ALTERNATIVE LANDSCAPE PLAN

MONUMENT ACADEMY

SITE DEVELOPMENT PLAN

LANDSCAPE PLAN - AREA 'A'

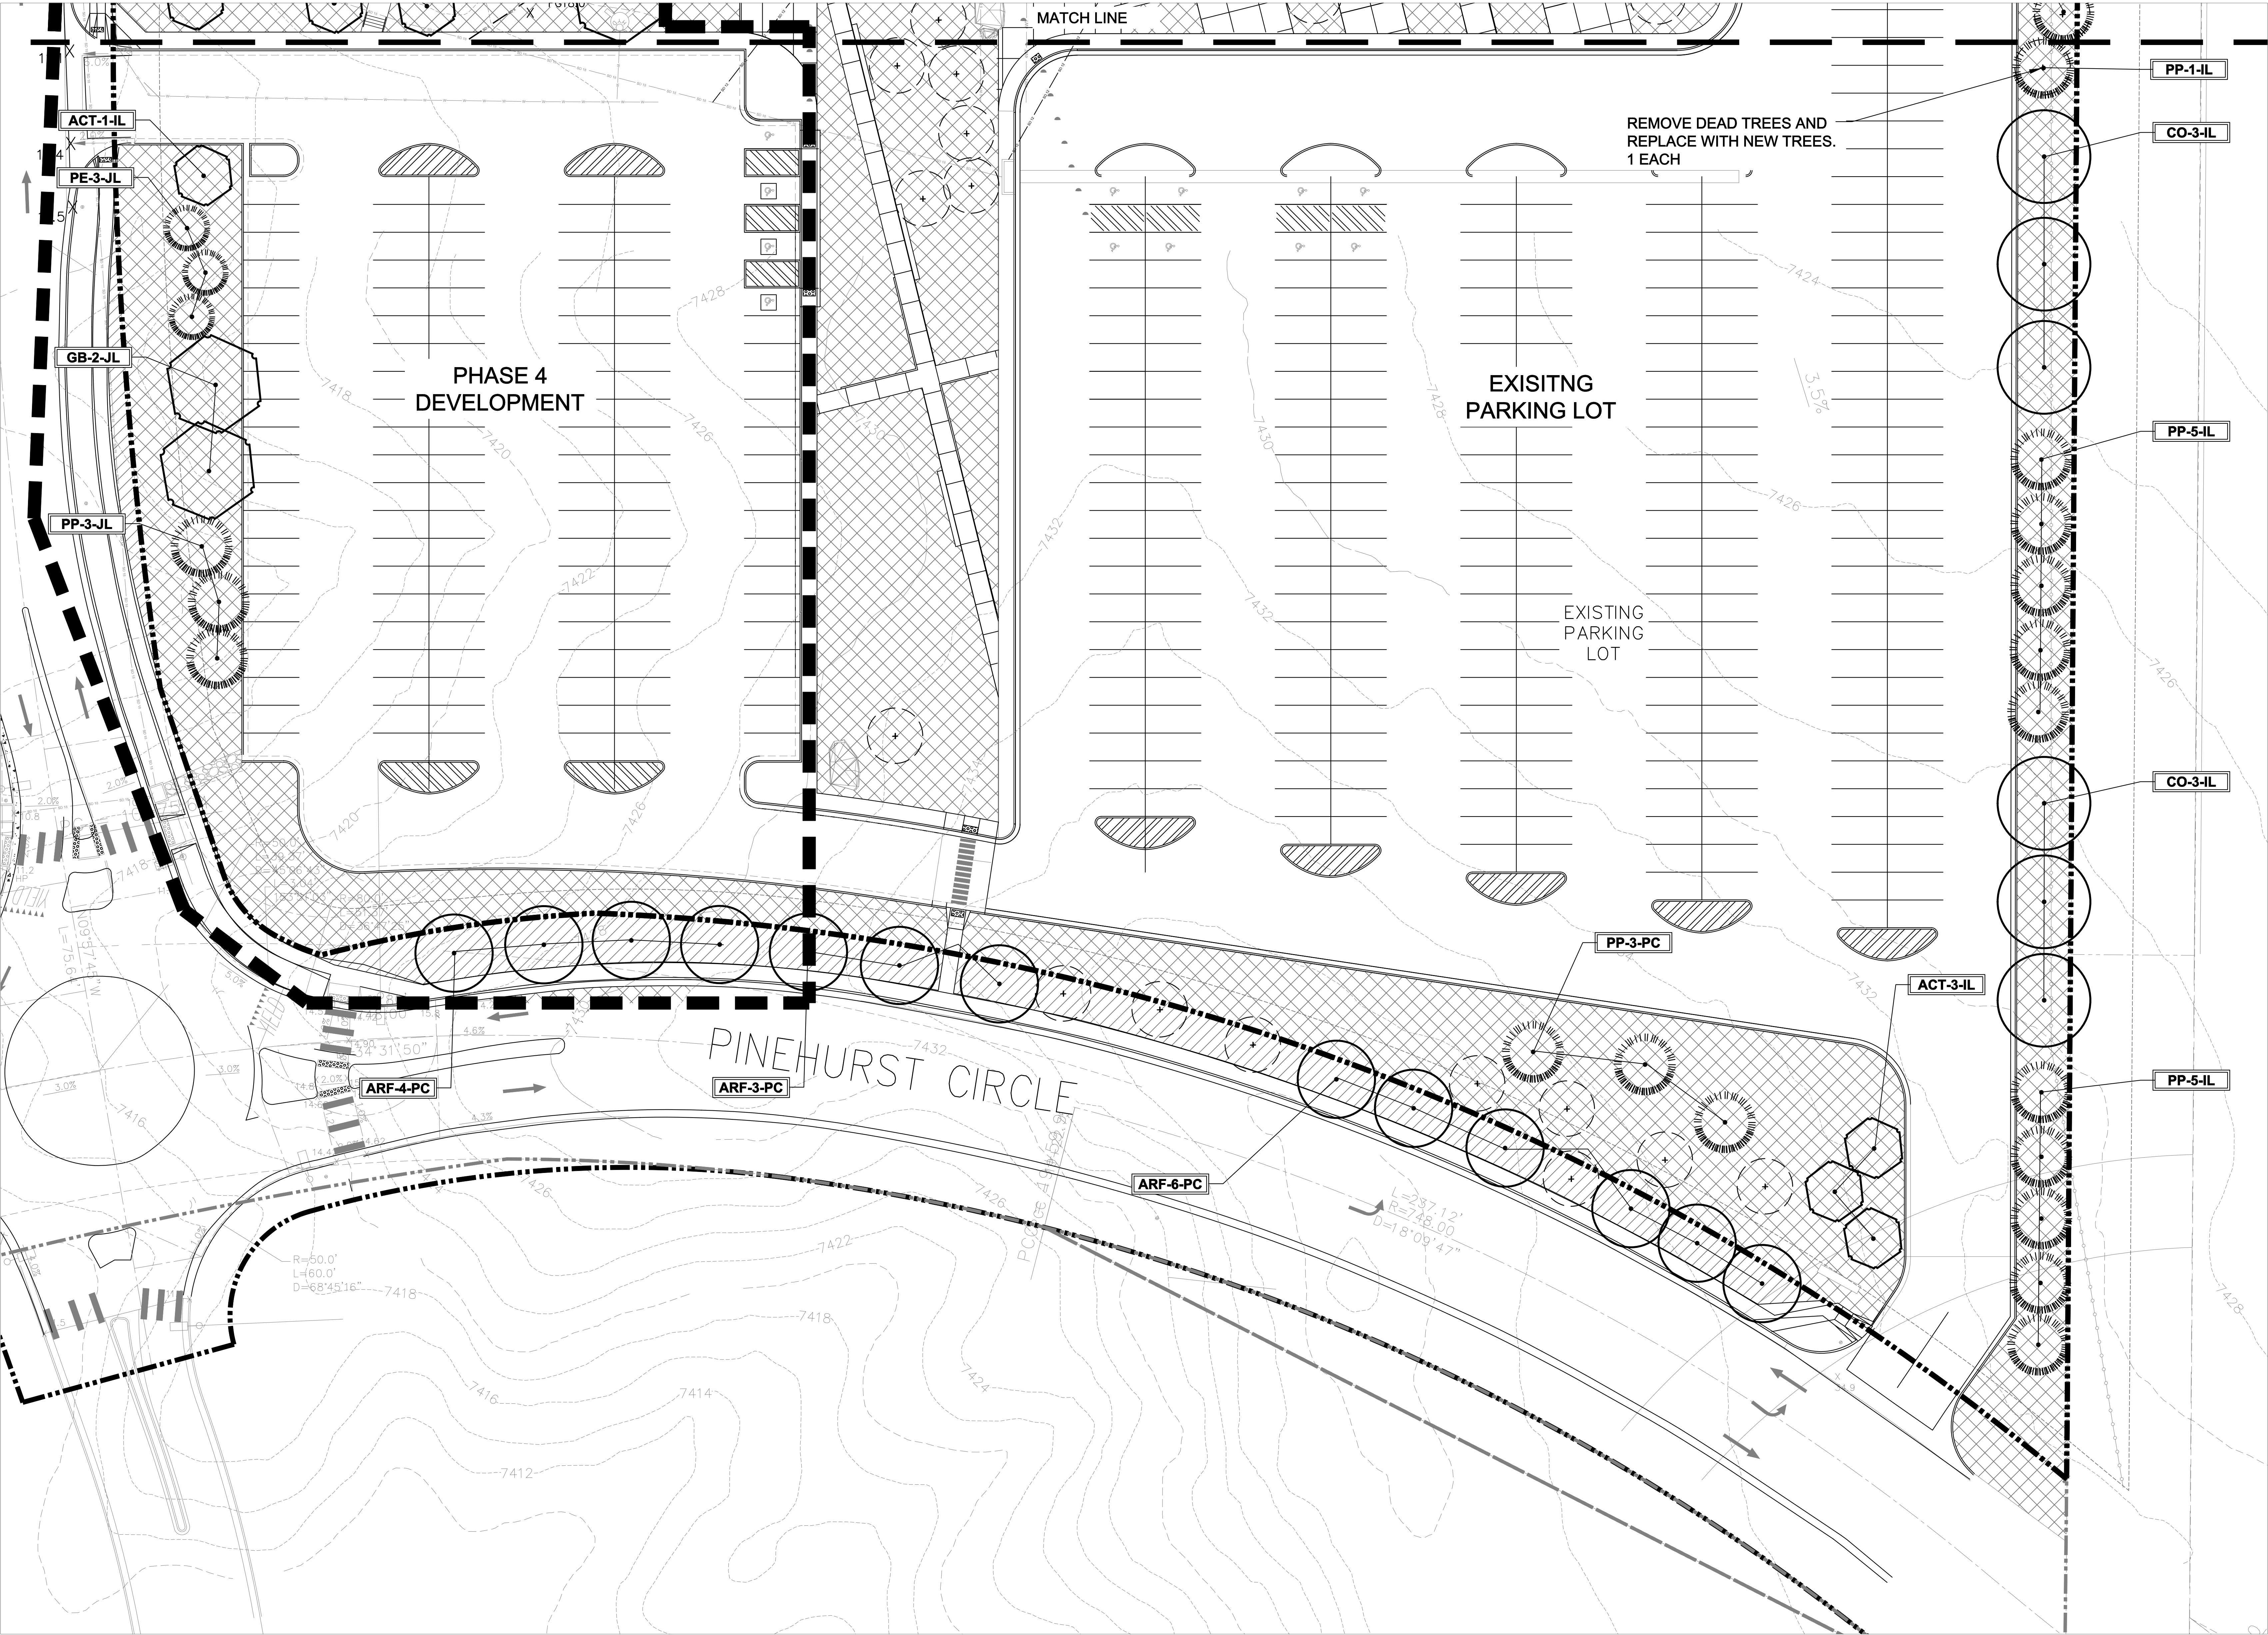
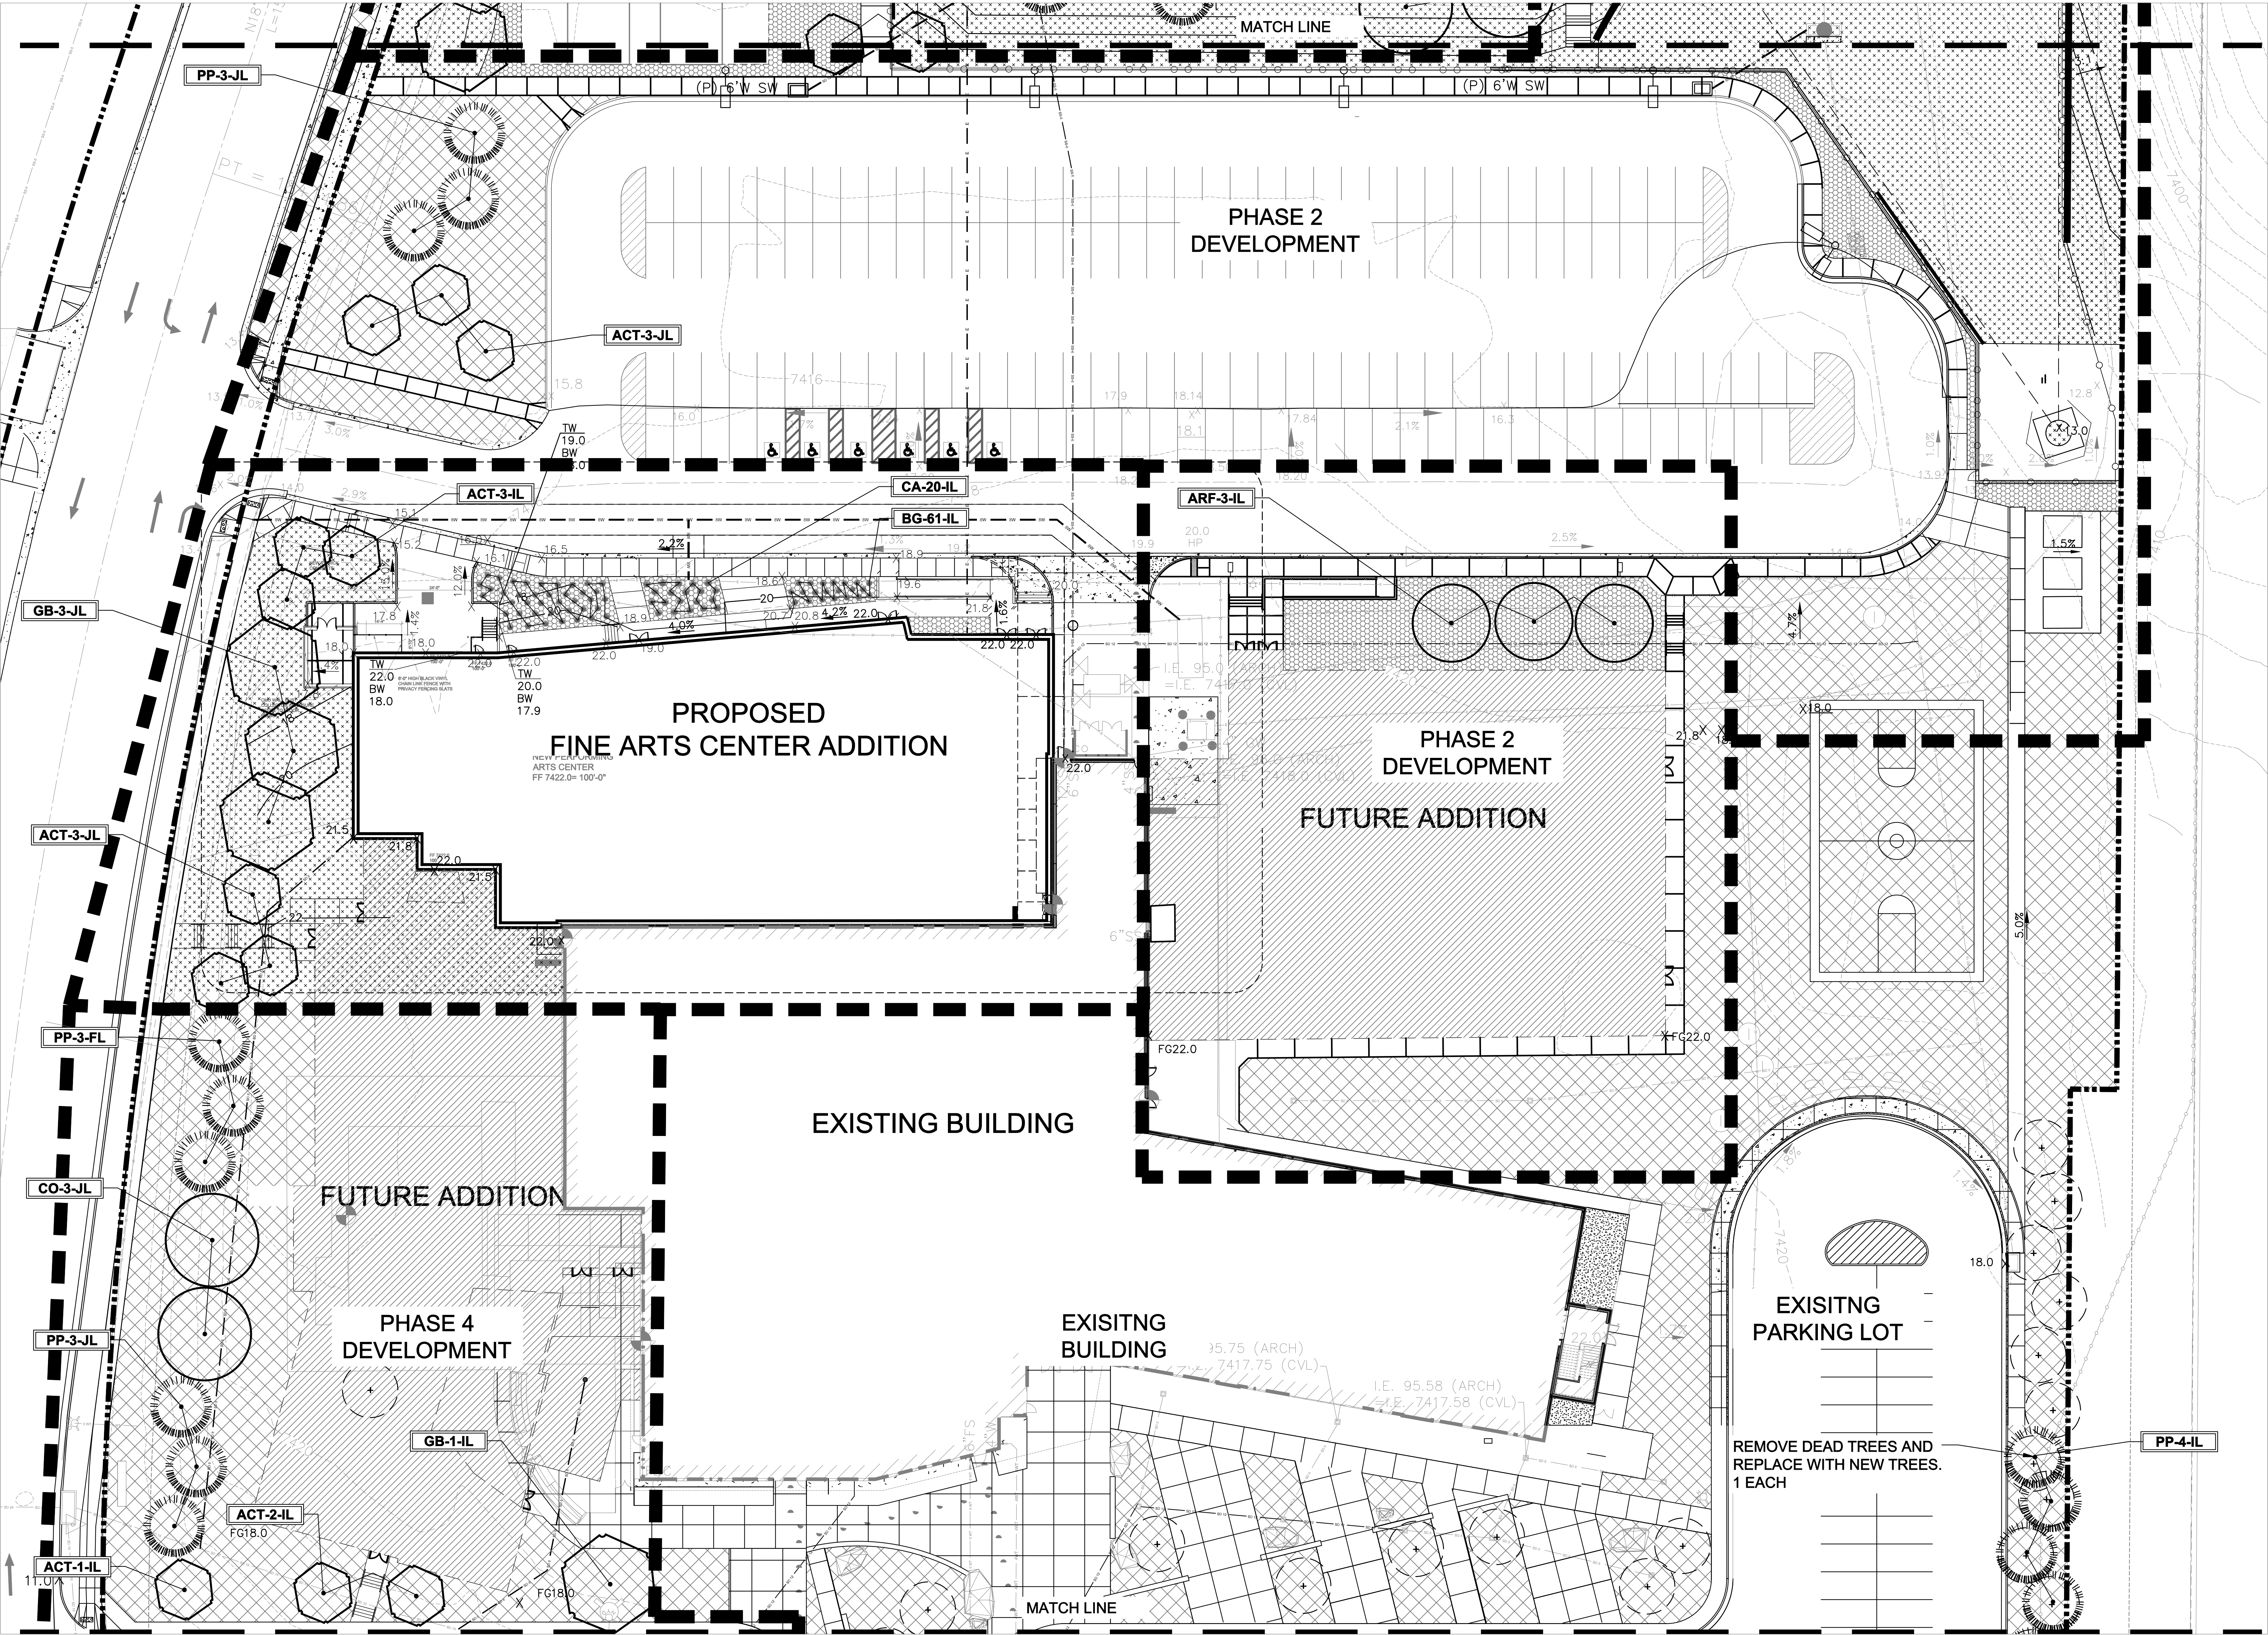
Roadway landscaping and buffer landscaping between uses may overlap. This means that the existing and proposed landscaping along all roadways may also count towards the buffer requirement. The PCD Director does not have the authority to waive a landscape requirement completely. Please update this section of the table to include the buffer requirement and the alternative design that will be proposed, if needed. After reevaluation, this requirement might be met with what is already depicted on the Landscape Plan. If needed, a specific alternative design (not waiver) will need to be requested and described in the Letter of Intent.

The PCD Director does not have the authority to waive landscaping requirements. Also, the previously approved Landscape Plan within PPR199 depicted interior landscaping which met the Code requirements. Please update this section of the table as well as the Letter of Intent.

See Letter of Intent comments regarding substitute design.
